**CITY OF ALBUQUERQUE
PLANNING DEPARTMENT
January 27, 2016
DRB Comments**

PROJECT # 1007715

APPLICATION # 16-70019

RE: Lot 1-A, Lands of Bryant and Whitaker

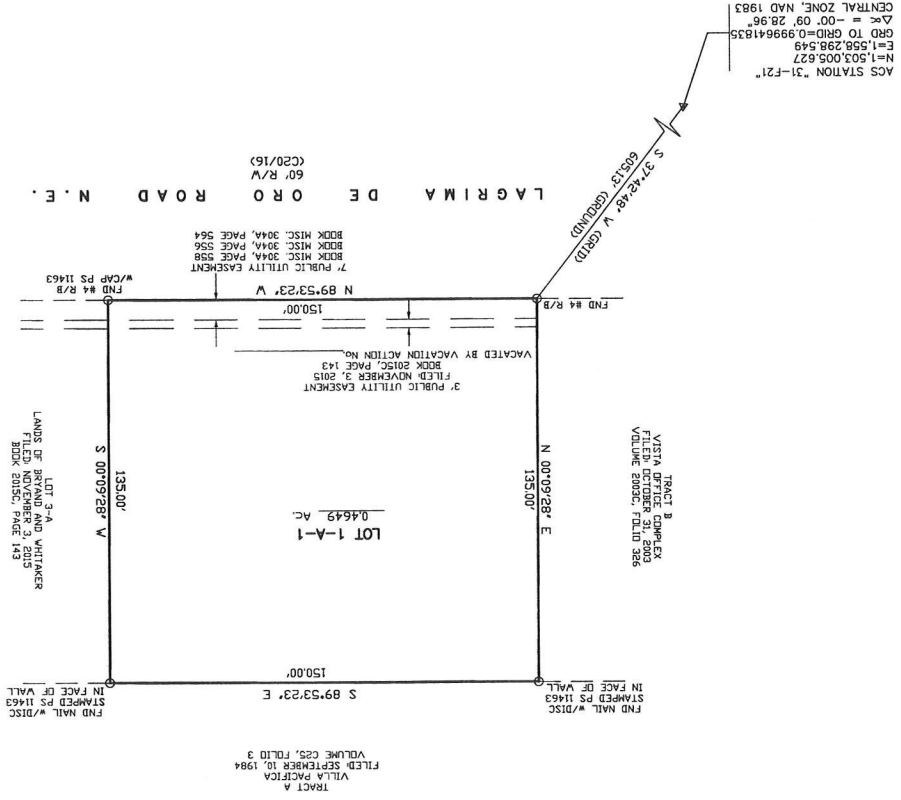
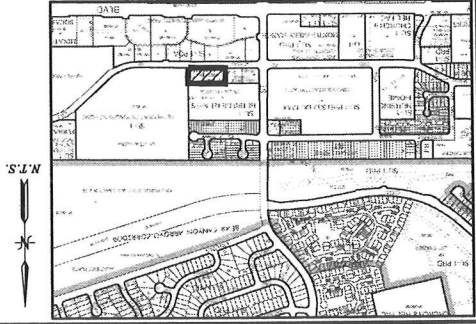
The title on Sheet 2 of 2 needs to be corrected.
